Weir Phillips Heritage and Planning

WOLLONGONG CITY COUNCIL SSD-73910208 REQUEST FOR INFORMATION

This Heritage response has been prepared to accompany a Request for Information from Department Planning, Housing and Infrastructure to the SSDA – 73910208 for the site at Nos 6-8 Popes Road, Woonona, New South Wales. The SoHI letter has specifically addressed the proposed works to the former Woonona Church on the site.

**Figure 29:** Proposed demolition. Breath Architecture.

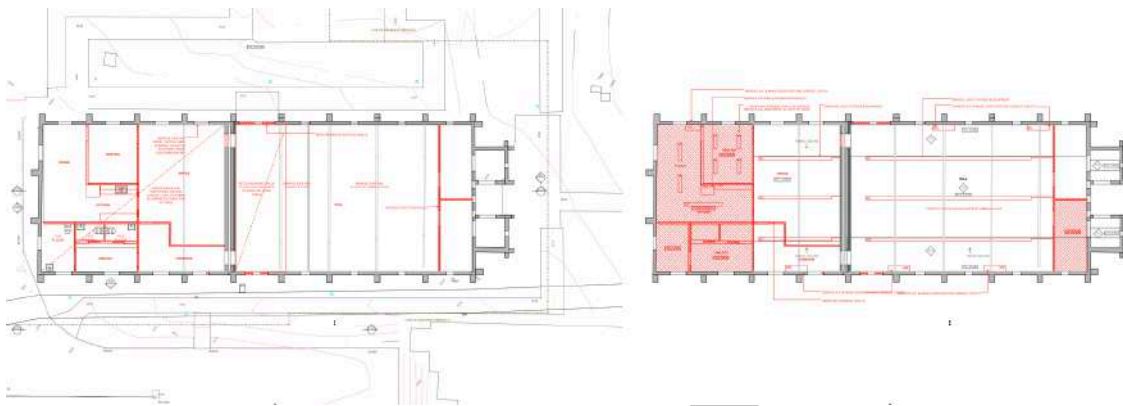
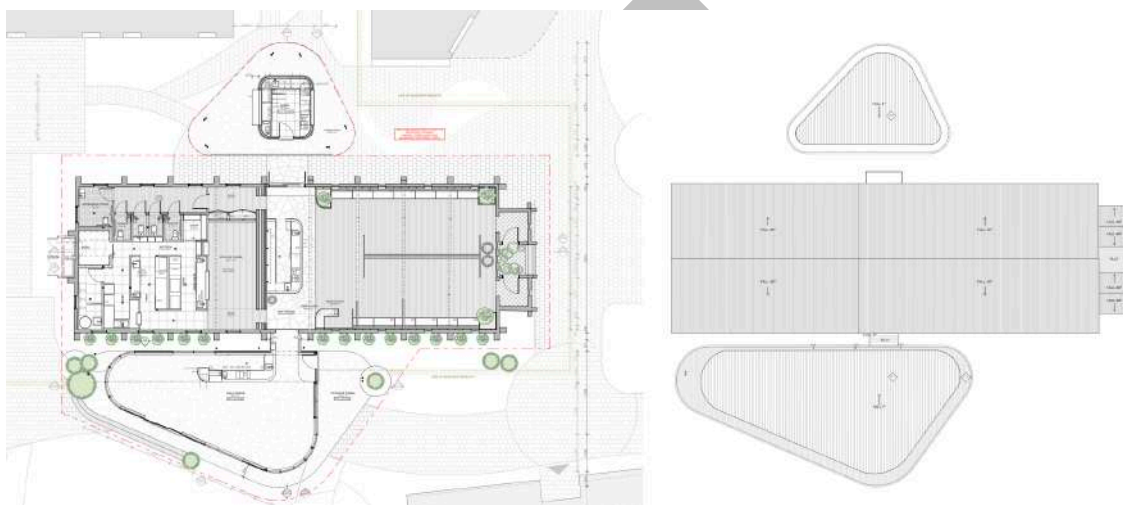
<p>obscured view corridors to the Church in this location and maintain the existing church setting and presentation from the public domain.</p> <p>Building D has been carefully designed in the context of the Church with a varied palette of materials, colours and restrained architectural detailing to enable able to sit comfortably with but recessive to the contrasting character and style of the Church.</p>
5	<p>RFI</p> <p>Adaptive reuse of heritage item</p> <p>13. The Department notes that limited information is provided about the internal fit out of the local heritage item for adaptive reuse as a restaurant / cafe. Please confirm the intended planning pathway for approval related to the design, fit out and operation of this space.</p>
5	<p>RFI RESPONSE</p> <p>IRT is requesting for approval in the SSDA for the adaptive reuse of the church building for a restaurant and café.</p>
6	<p>RFI</p> <p>The EIS and HIS notes that internal reconfiguration and demolition works are proposed to the Church building to support a change of use to a restaurant and all fit out and services will be reversible.</p> <p>However there are no plans or detail of what work is proposed to the church building, how the additional pavilion and kiosk would function, what is proposed to be accommodate in the church building (kitchen, storage, dining etc). Floor plans and demolition plans are requested for the heritage item, and additional structures.</p>

6	<p>RFI RESPONSE</p> <p>The architectural drawings have now been revised to include plans and detail of the work proposed to the church building to adaptively re-use it as a restaurant and cafe, how the additional pavilion and kiosk will function, what is proposed to be accommodated in the church building (kitchen, storage, dining etc). Floor plans and demolition plans of the heritage buildings are now provided. Refer to the revised SSDA submission.</p> <p style="text-align: center;">Impact of the Proposed Works on ‘Former Woonona Uniting Church’</p> <p>The Former church is comprised of two attached halls, the principal front hall and rear, secondary hall. Refer to Figure 33.</p> <div style="text-align: center;">  <p>The floor plan shows the layout of the church building, divided into a Secondary Hall (left) and a Principal Hall (right). The Secondary Hall contains a Dining area, Meeting room, Office, Kitchen, Airlock, and Corridor. The Principal Hall contains a Hall and a Corridor. The plan is annotated with red lines and text indicating proposed demolition and construction work, such as 'REMOVE EXISTING PARTITIONS, CEILING, LINEN, LIGHT FIXTURES, PLUMBING FIXTURES AND FITTINGS', 'REMOVE EXISTING CARPET FLOOR', 'REMOVE EXISTING FLOATING TIMBER FLOOR', and 'REMOVE EXISTING WINDOW FOR REUSE MAKE GOOD EXISTING BRICKWORK'. A blue dashed line outlines the perimeter of the building, and a red dashed line outlines the perimeter of the proposed works. Labels 'SECONDARY HALL' and 'PRINCIPAL HALL' are placed below the plan.</p> </div>

- The principal significance of the hall interior is its internal volume created by the raked timber ceiling and arched windows which are retained.
- The proposed works to principal hall are minor in scale including the removal of the contemporary partition walls and rooms to the front of hall, near the entry and will help reinstate the original open plan of the hall.

- The partitions walls will be carefully removed to ensure there is no damage to any significant fabric.
- The two arch windows proposed to be removed will be carefully removed, protected and securely stored on site. It is also possible that they could be displayed within the church. The new openings created by the removal of the windows will enable compliant access to the proposed pavilions and will be carefully undertaken removing as few bricks as possible and openings made good with new joinery.

- The secondary hall has been previously modified with a lowered ceiling and internal rooms to half of the hall.
- The proposed ceiling will extend the existing lowered ceiling to all of the secondary hall with the more significant raked ceiling retained above.
- The removal of the internal layout and joinery is either contemporary and less significant. It will be carefully removed to ensure no damage to the heritage fabric.
- Self-supporting stud walls will be constructed adjacent to the significant heritage walls to enable the installation of new joinery, hydraulic and electrical services to prevent any physical impact on the heritage walls.
